**RE: Sunset Gardens Subdivision (File: K12D003)**  
**Drainage Report, Engineer's Stamp Date 1-19-15**  
**Grading and Drainage Plan, Engineer's Stamp Date 8-20-15**

Based upon the information provided in your submittal received 8-20-15 the above referenced submittal is approved for Building Permit, with the following conditions:

The following items need to be corrected/shown/provided for the Work Order Construction Set:

TITLE: **SUNSET VILLA**
GARDEN WAY STORM DRAIN IMPROVEMENTS 2

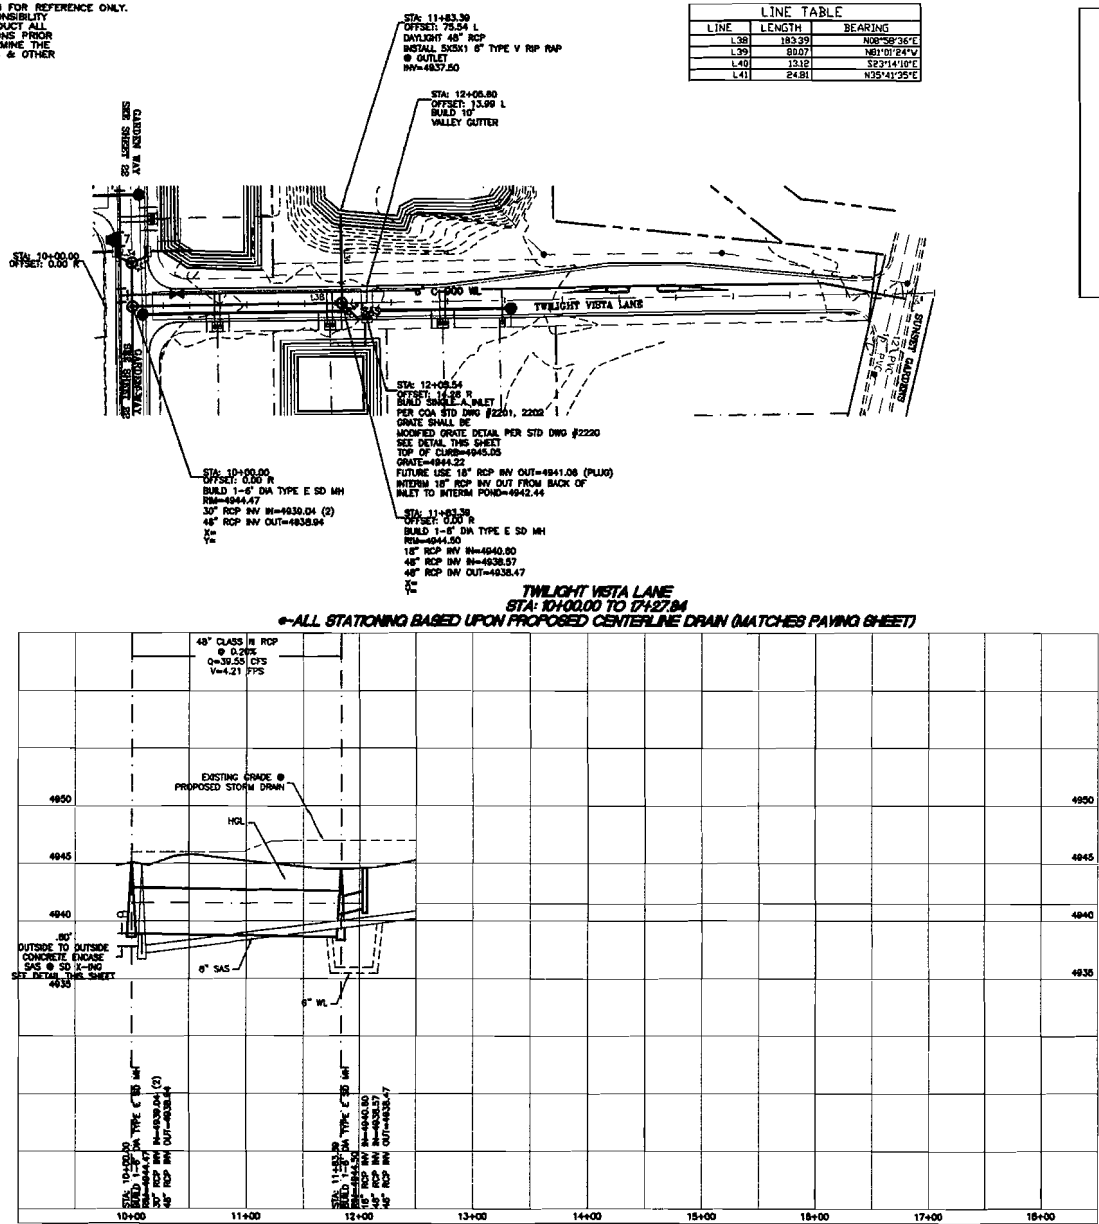
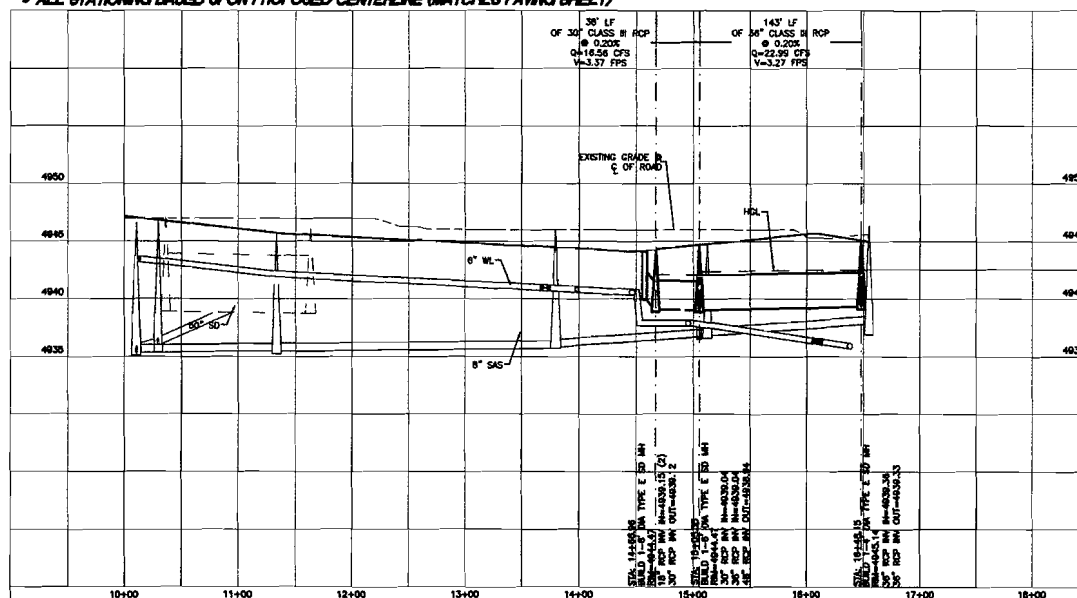
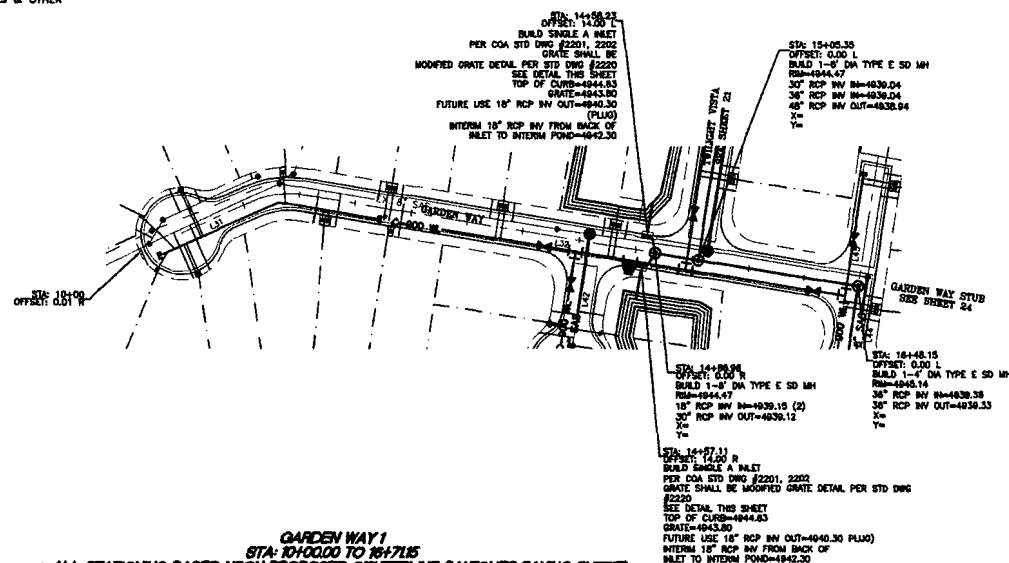
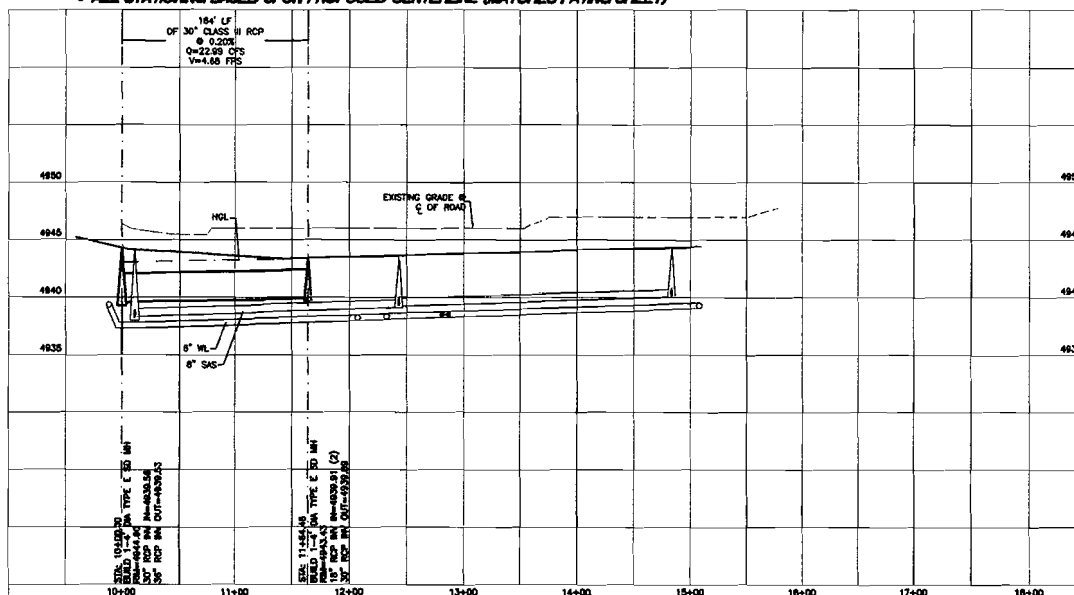
1. Show removal of the Existing wall in the roadway near Powell
2. Roadway tract needs a paper drainage easement prior to DRC
3. Obtain a Flood plain permit for construction in the flood zone prior to DRC
4. Provide inlet detail. Show how the bottom is to slope for the interim condition, and how it is intended to be modified for the future condition. (The inverts into pond are lower than the "future use inverts." When the inverts to the pond are plugged in the future, lean fill can be poured to slope the bottom of the inlet to the "future use" invert. )
5. Adjust the Flowline El. And T.O.Curb Elev. at inlet discharging to Pond E. F.L and Grate are shown at same elev. and grate cannot be lowered as it is already at the MAX WSEL of Pond E.
6. Correct the "INLET TO INTERIM POND =4942.30" for inlets discharging to Ponds D and E. Invert should be less than the "FUTURE USE INVERT OUT=40.30"

SUNSET VILLA GRADING AND DRAINAGE PLAN	DRAWN BY: MCKI DATE: 1-19-15 21401-1000-1-06-13
	1/19/15 DAVID SOULE P.E. #14359	Rio Grande Engineering 1400 CENTRAL AVENUE, SUITE 200 ALBUQUERQUE, NM 87102 (505) 975-0000

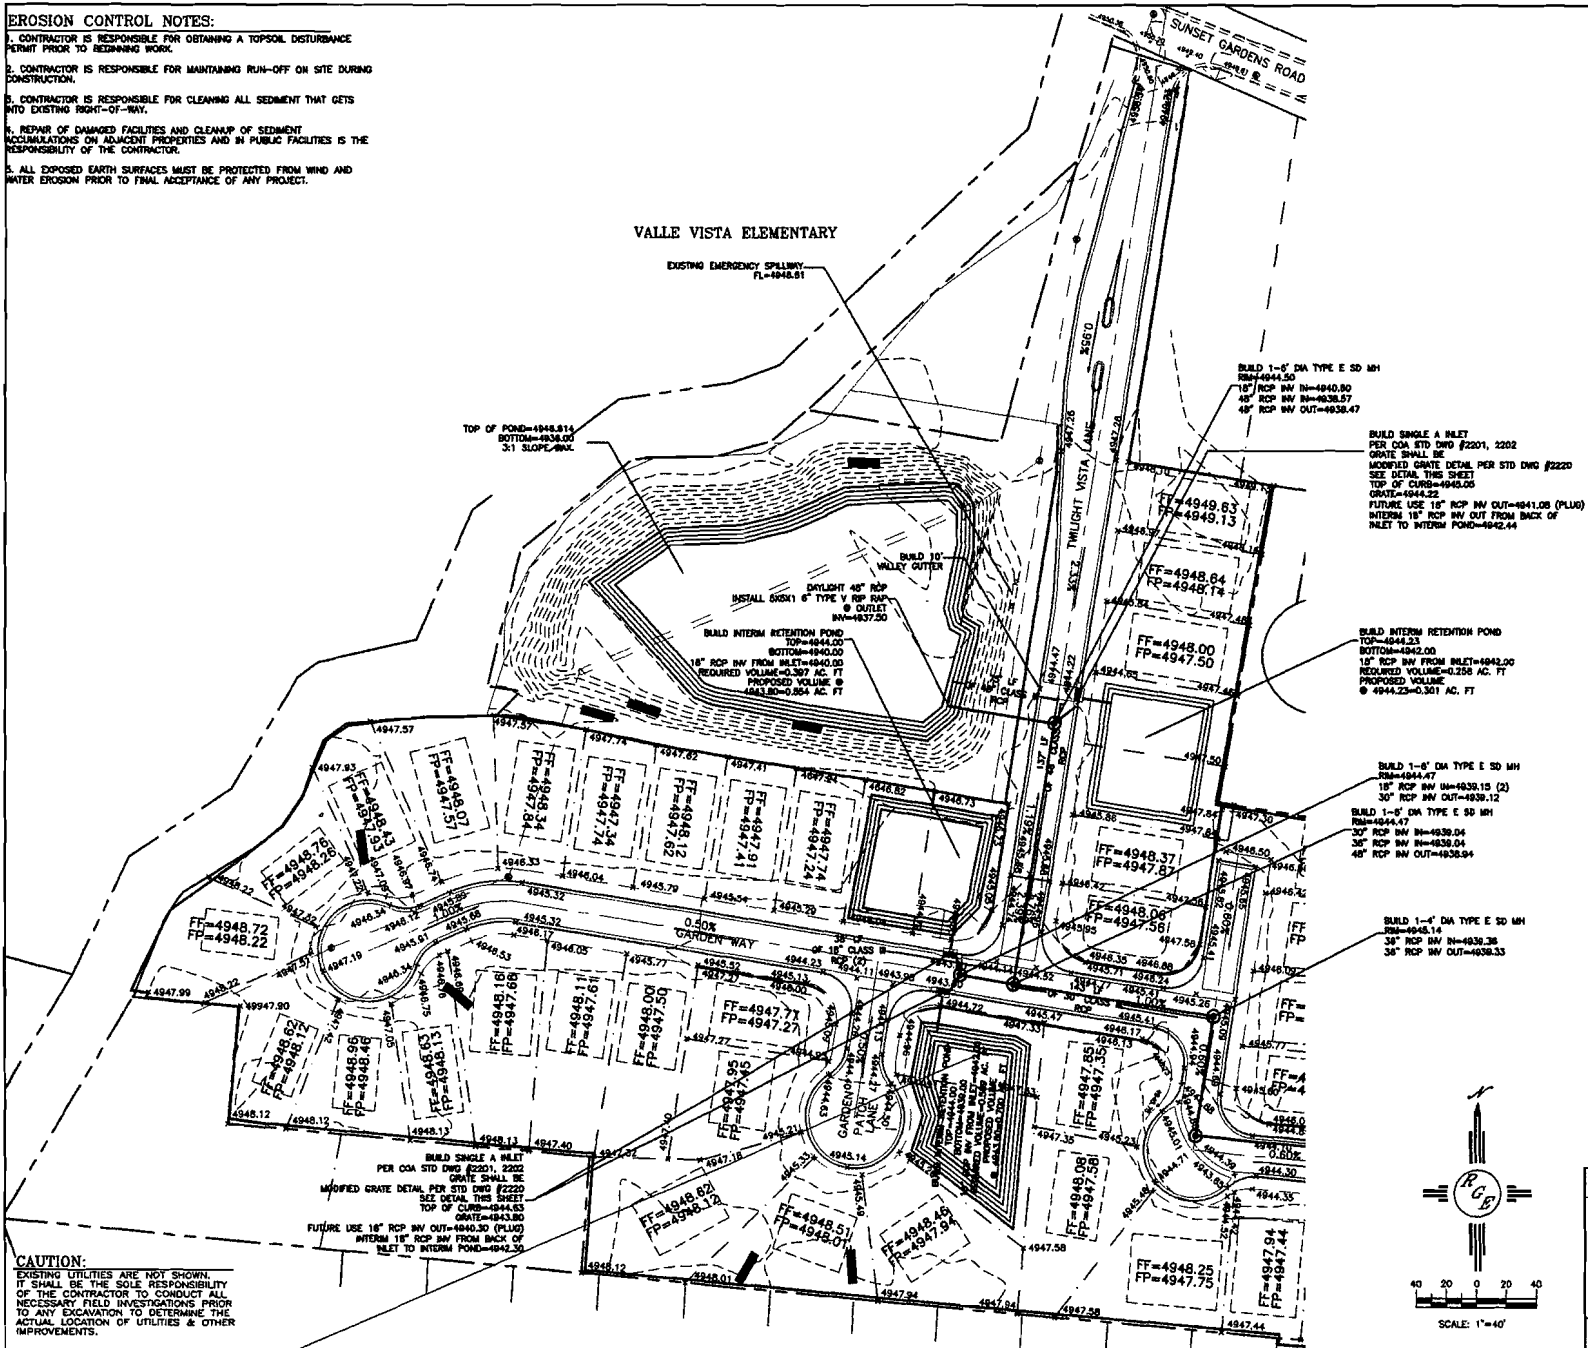
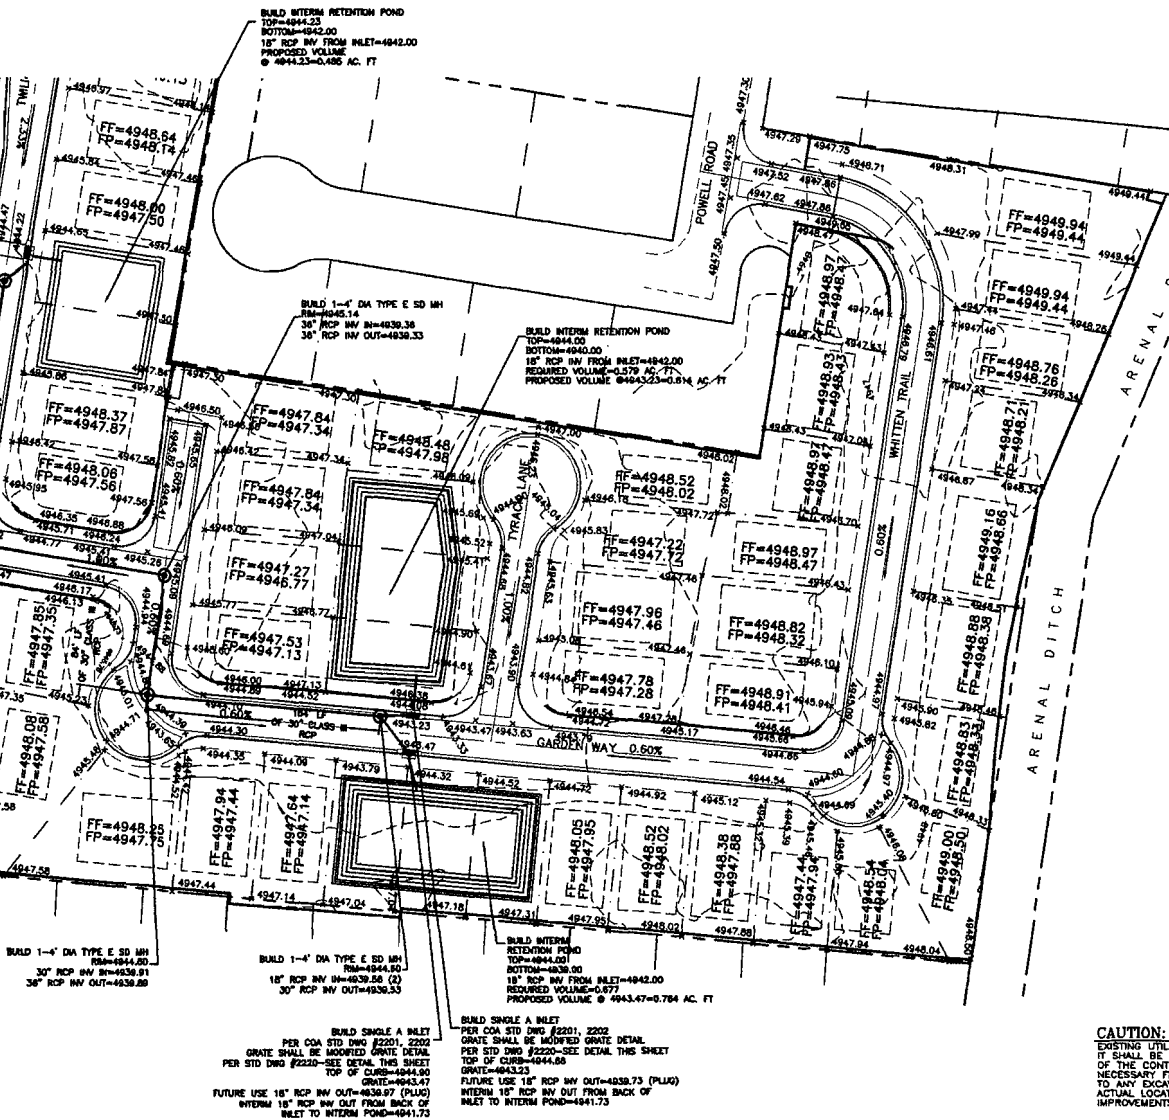
- 1) It is noted that this project was originally designed and approved by others, and the site has already been rough graded. The pad elevations are intended to remain the same as the original design. However, the road design changed and is sloped to allow for surface drainage. As a result Lot 13 (and other lots) has a pad that is high relative to the road resulting in a drive pad with a 16% slope. Pad elevations need to be adjusted such that the drivepad is at a maximum of 15% slope. This should be reflected both on the Work Order Construction set and the Engineer's Certified plan .
- 2) A LOMR-F is required prior to Building Permit for lots 46 and 47
